27 October 2025

Re: Canterbury Bankstown City Council Submission to the State Significant Development Application, SSD-83256463 – 150 The Boulevard and 34 Dudley Street, Punchbowl, Punchbowl, Homes NSW Affordable Housing Development

Attachment A - Summary of Additional Information, Amendments and Recommended Conditions of Consent Requested by Council

Attachment B - Detailed Comments

Drawing number+ revision	A_SSDA_513	B
--------------------------	------------	---

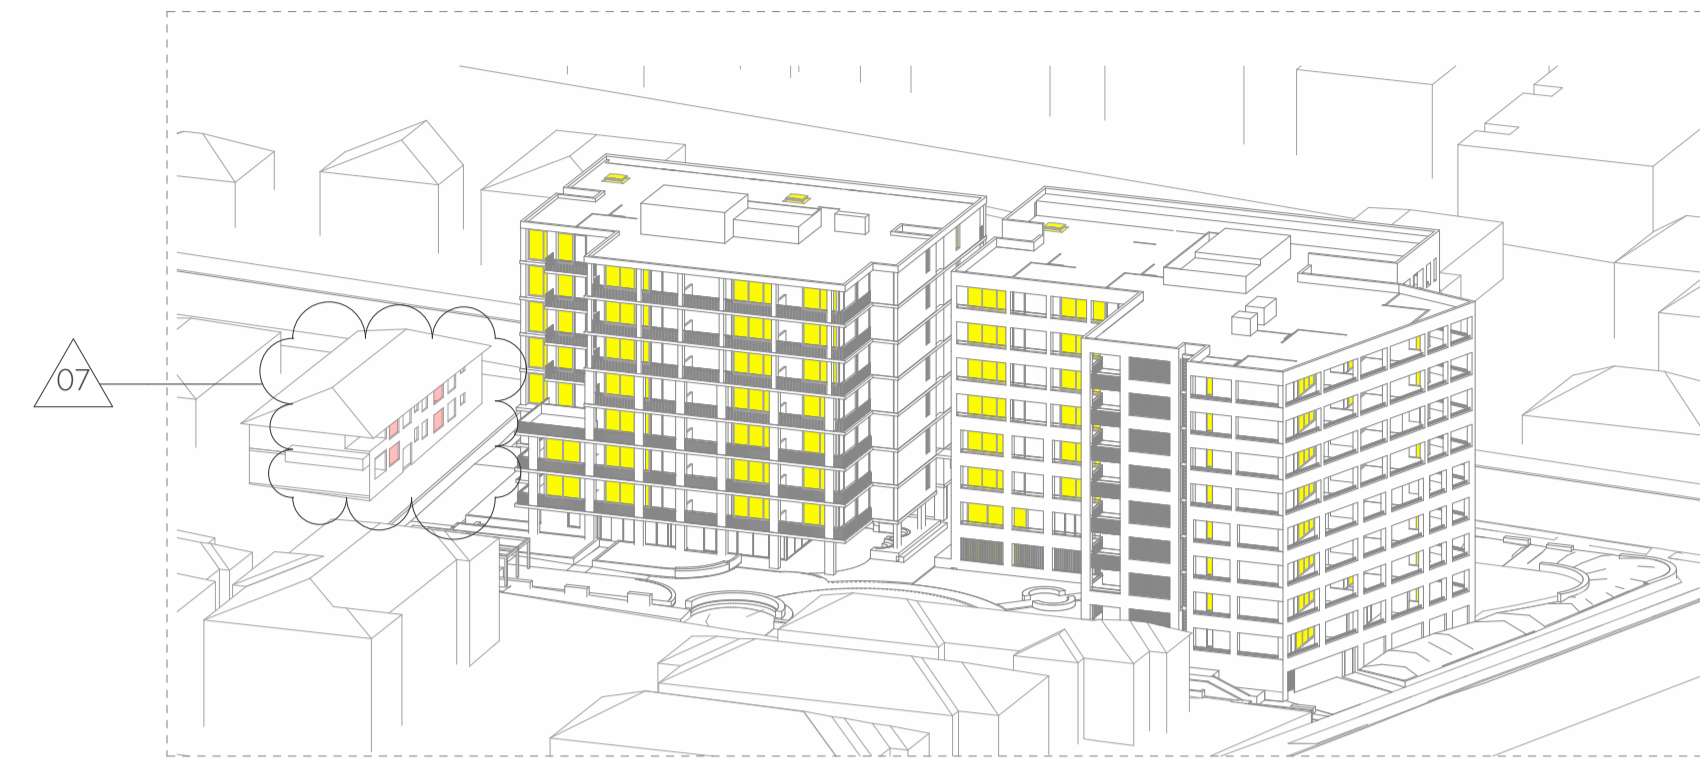
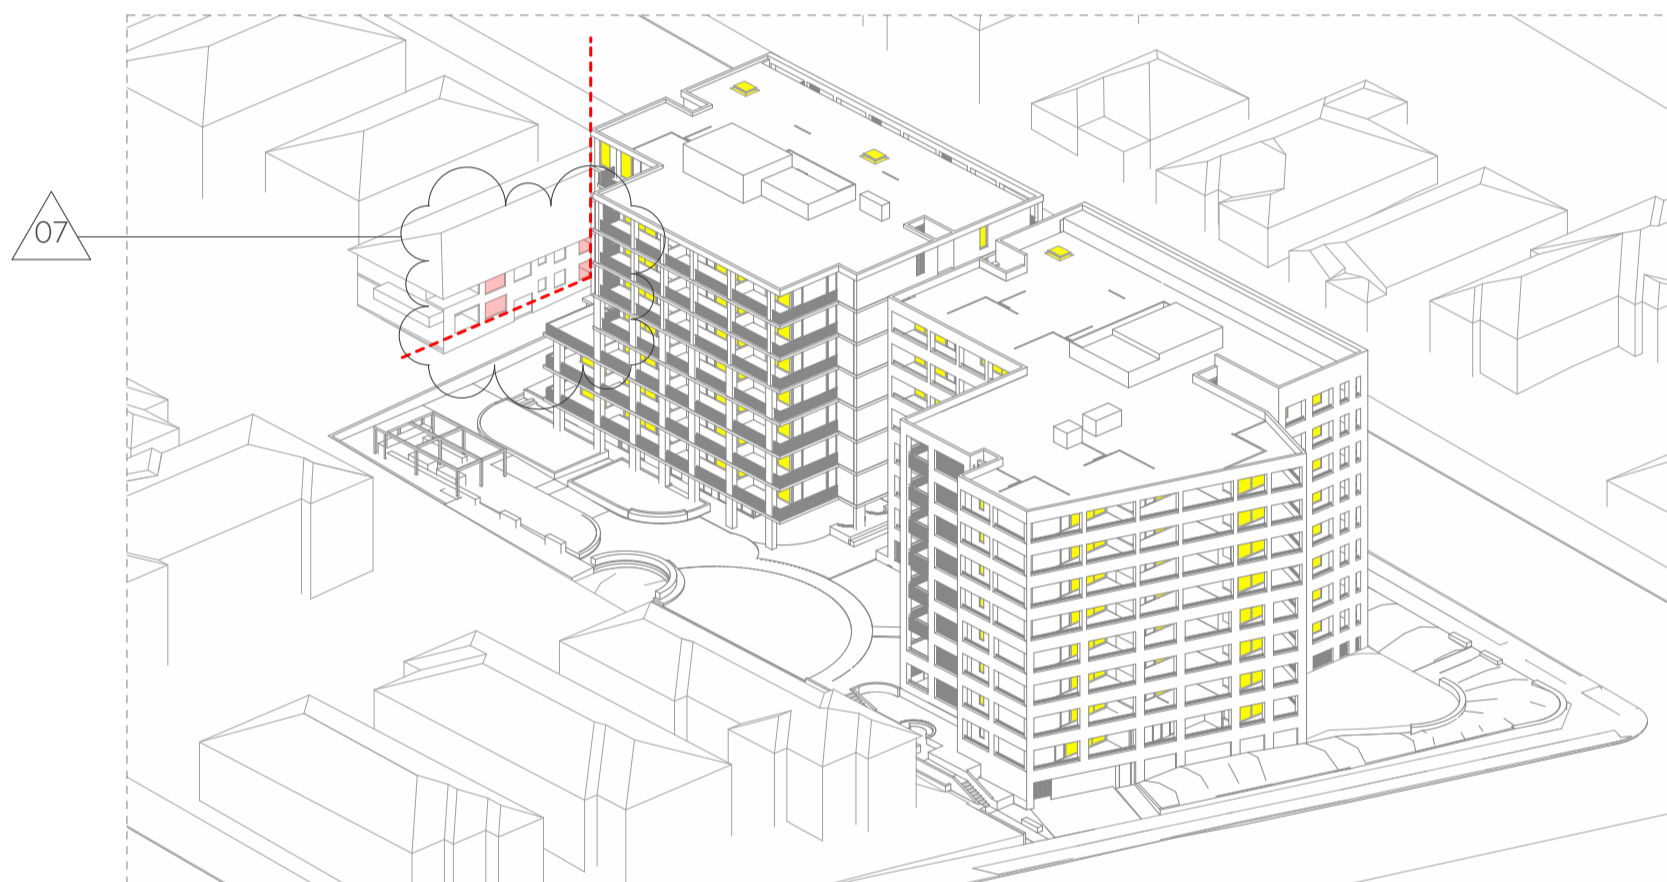
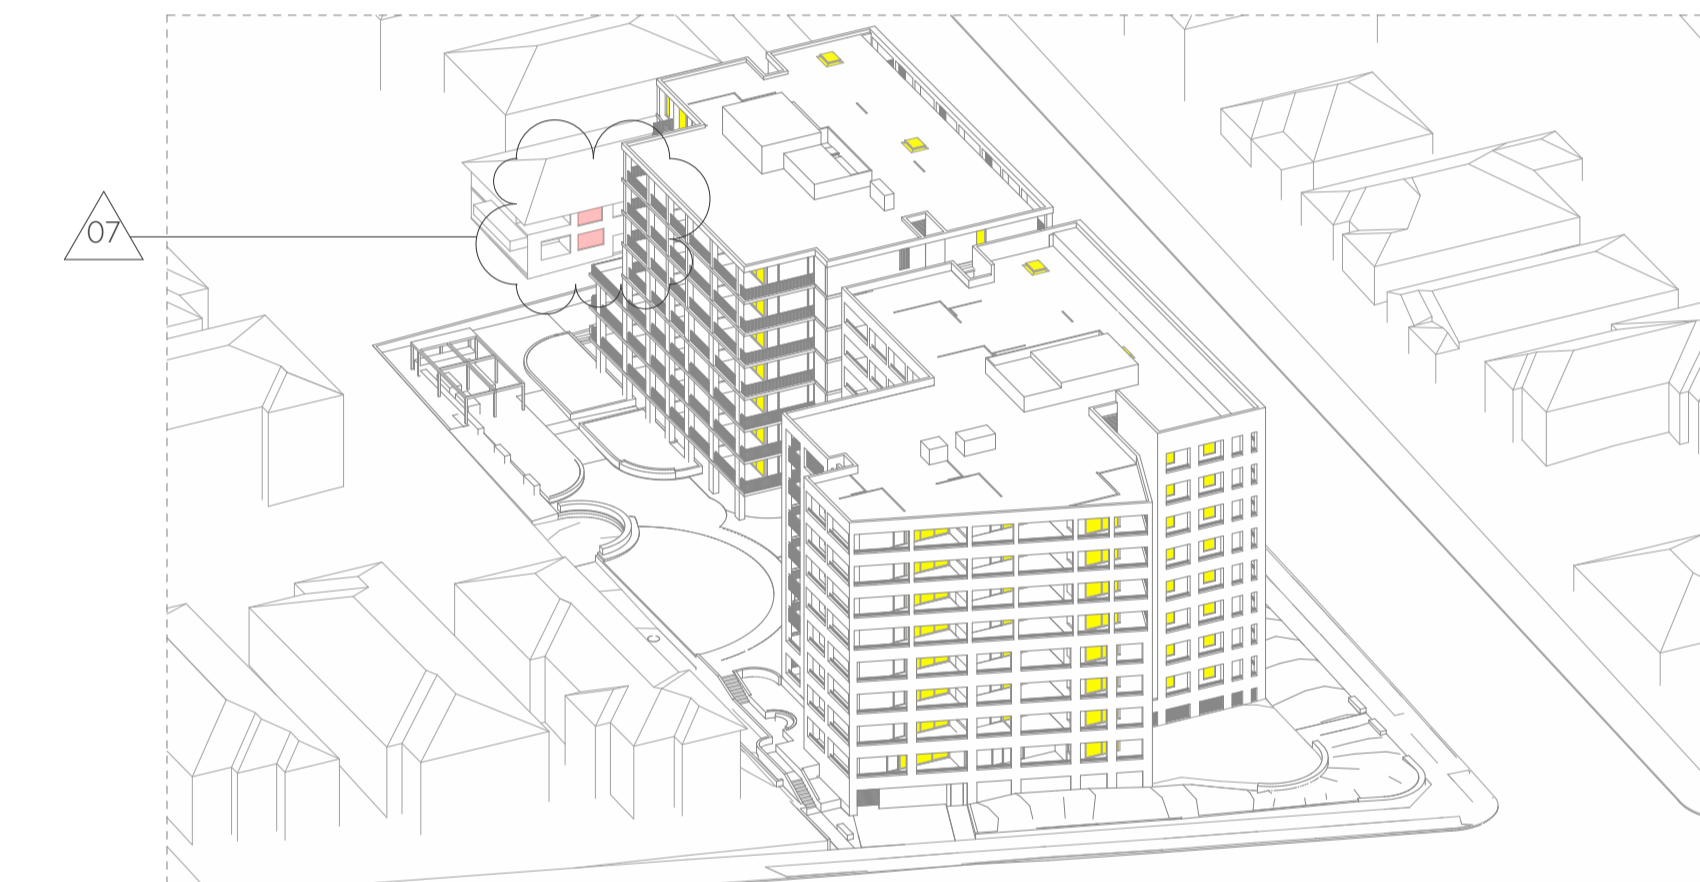
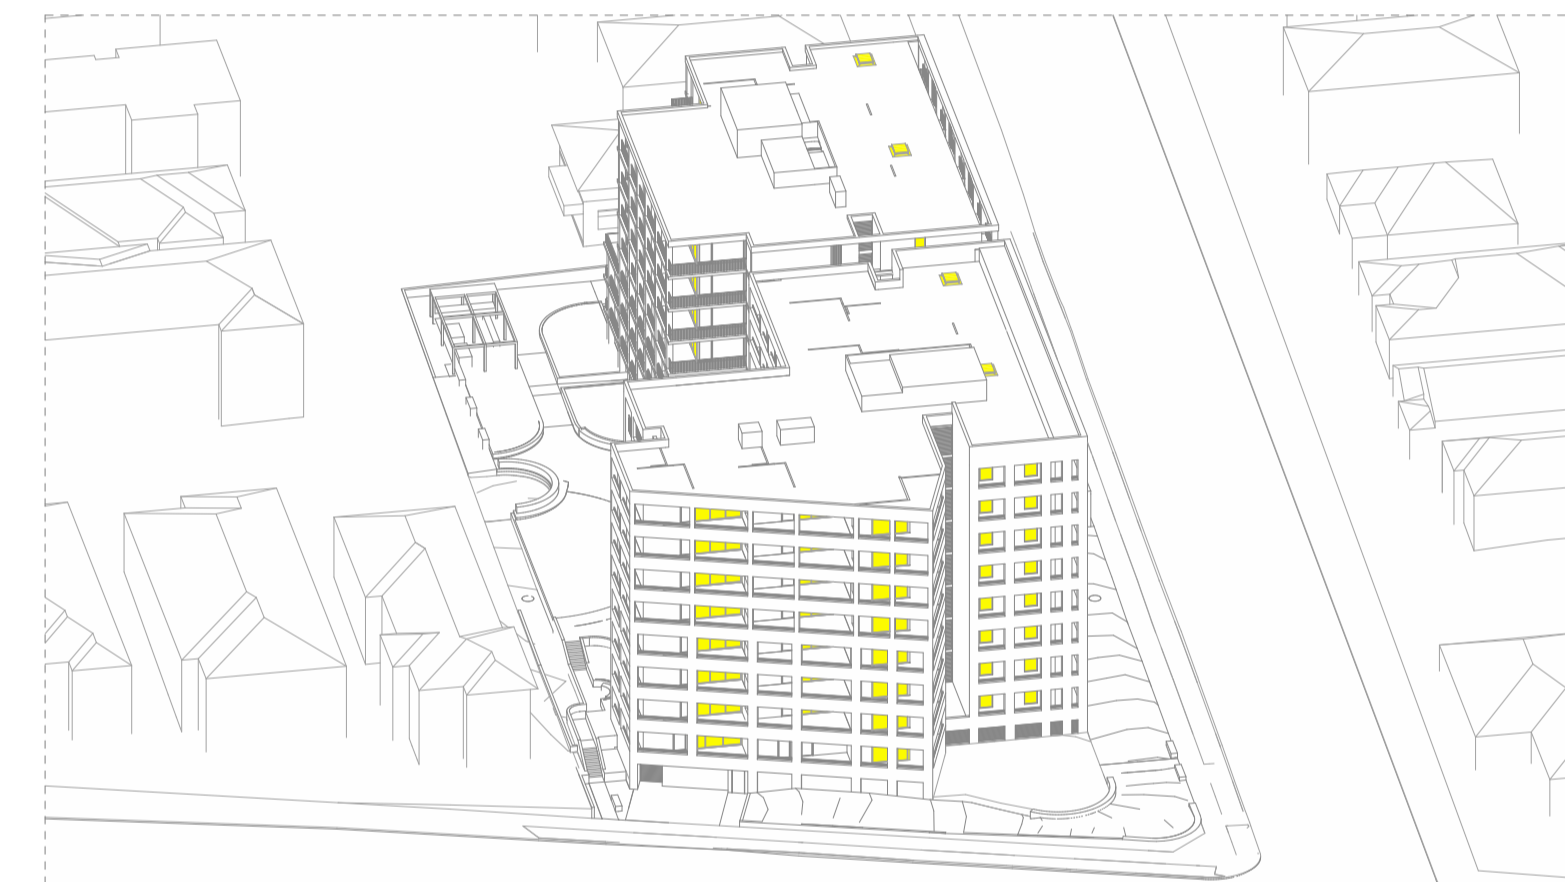
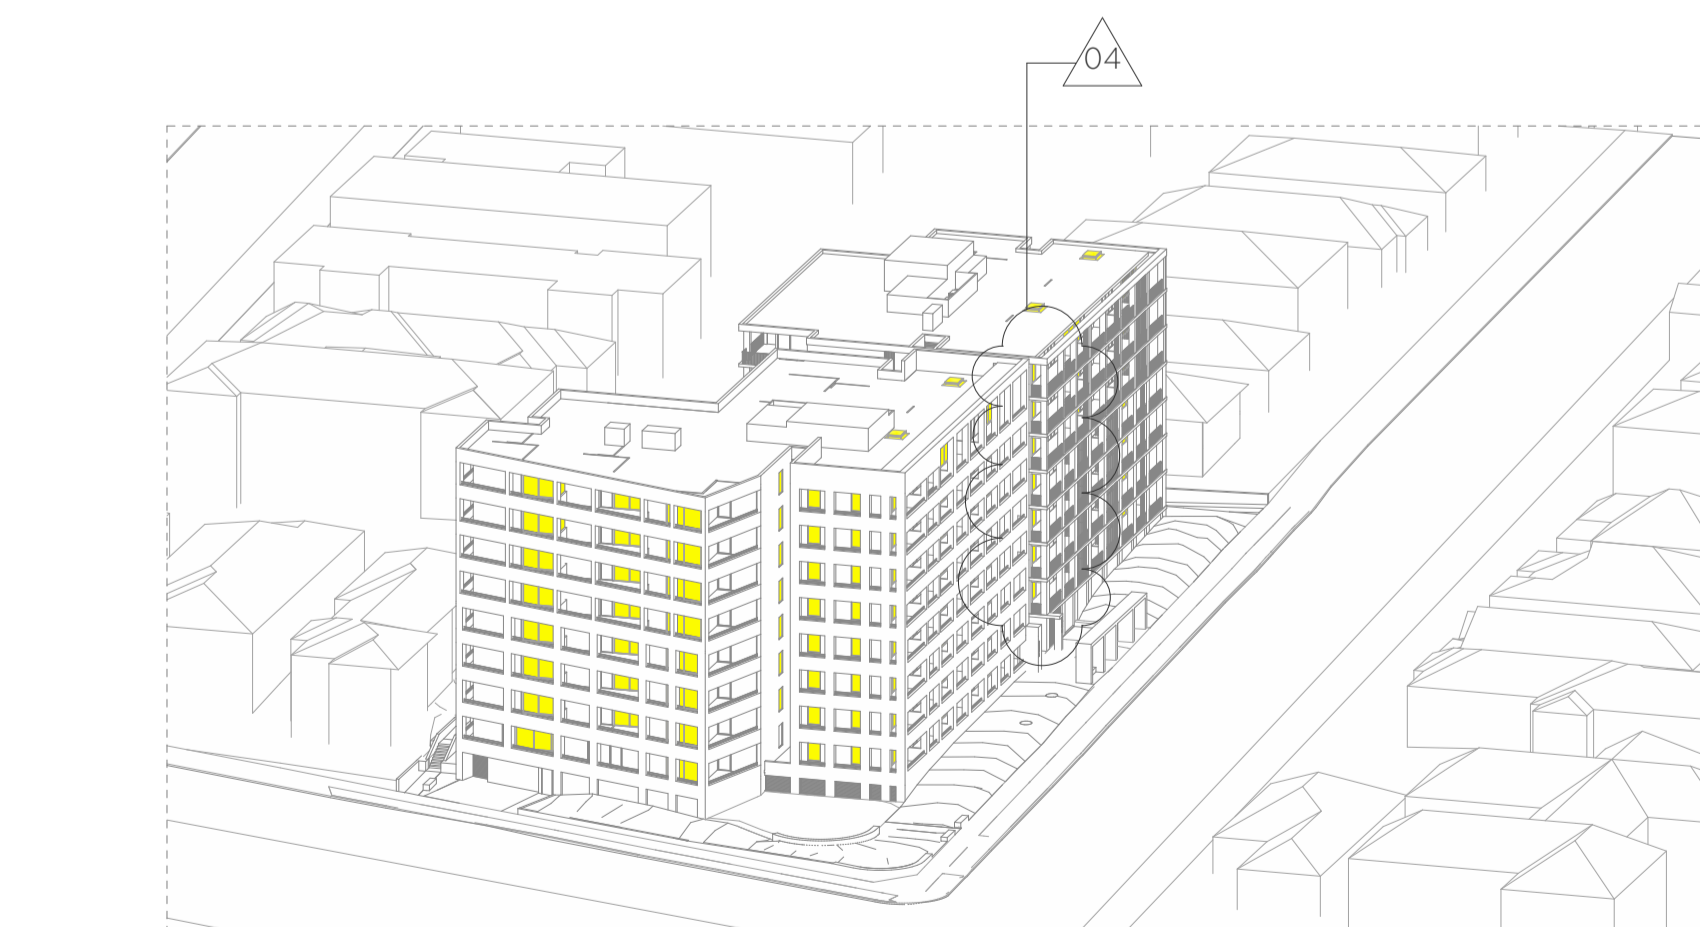
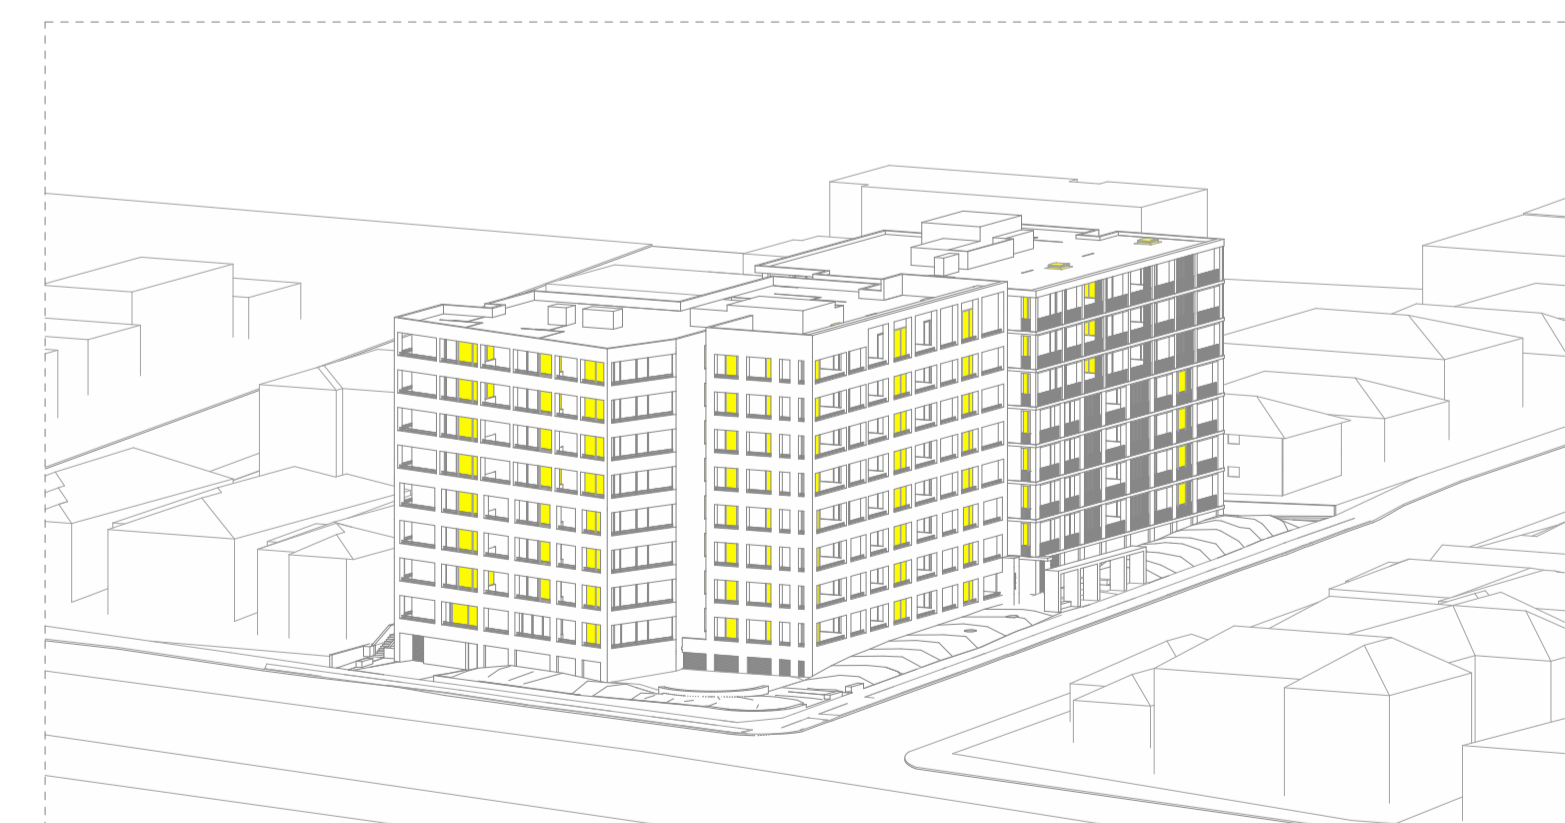
Category	Council Feedback
	<u>Recommendation:</u> That the following be provided: • Amended plans be provided that comply with 3F; or • Environmental planning reasons be provided to justify the non-compliance. <u>Solar Access to 36 Dudley Street</u> 1.4 To the south of the site is a two storey Residential Flat Building (RFB) at 36 Dudley Street. The SSDA Design Report advises this RFB as two northern elevation living room windows (one on each level for Units 1 and 4) which must each receive at least two hours sunlight between 9am and 3pm in midwinter.  North Elevation of 36 Dudley Street.  Living room windows requiring retained solar access However, Councils records (file 253/36B) show this RFB as having two additional living room windows (relating to units 3 and 6) and which are the two easternmost windows on the northern elevation. <u>Recommendation:</u> • Amended plans be provided that accurately show the living rooms on the RFB at 36 Dudley Street and them receiving adequate solar access in midwinter. <u>Solar Access to western facing dwellings</u> 1.5 The failure for the western facing units to receive two hours sunlight between 9am and 3pm in midwinter is not supported and indicates the design response has not been adequately considered. The applicant's reliance on extending this window from 9am to 4pm is not supported. <u>Recommendation:</u>

Category	Council Feedback
	Amended plans be provided which demonstrate western facing dwelling received adequate solar access between 9am and 3pm.
3D Model (digital)	The applicant is to provide a digital 3D model for assessment and community engagement, in line with Council's 3D Model Submission Manual. https://cb.city/3D-Model-Submission-Manual
Urban Design	The proposed development is generally supported, pending some modifications to improve internal amenity, façade design and landscape outcomes. Ordinarily, this type of development would trigger the Council's Design Excellence requirements under Clause 6.15 of the Canterbury Bankstown Local Environmental Plan 2023 (CBLEP 2023) and would be required to achieve high standards of design quality and amenity that go beyond the base requirements of the Apartment Design Guide. 1. Bulk and scale 1.1 The proposed development exceeds the current FSR and Maximum Height of Buildings controls (0.9:1 and 11.5m), even when accounting for the 30% affordable housing bonus (1.17:1 and 14.95m). Nevertheless, the proposed built form sits comfortably within this emerging urban context envisaged in the Wiley Park and Punchbowl Masterplan, which anticipates FSRs of 2.5:1 and 1.7:1, and building heights of up to 33m and 23m respectively. <u>Recommendation:</u> None. 1.2 While a 1.5 m parapet offset is provided between the two buildings to create a sense of transition and enhance the skyline, it is too subtle to be perceived from pedestrian level and across the sloping grade. In addition, the consistent grid alignment and similar façade proportions visually unify the pair, reducing the effectiveness of the intended solution. <u>Recommendation:</u> Achieve a stronger distinction between the two buildings through deeper material contrast, varied balcony treatments, or differentiated roof termination. 1.3 While the proposed eight storey form, with no defined street wall height, may be supported in this context, the design should break the continuous vertical expression and visually define a mid-level break that respects the desired street wall datum and reduces perceived bulk (the draft DCP controls will be exhibited soon). - See further comments under point 3.1. - Refer to the images below for additional references, including a previous façade design version for this development. <u>Recommendation:</u> The façade strategy should reinforce varied material selection, lighter colours or strategic recesses above the intended street wall height, to clearly express a distinct street-wall datum and achieve a more balanced street interface. These refinements will ensure a stronger built-form response, enhanced
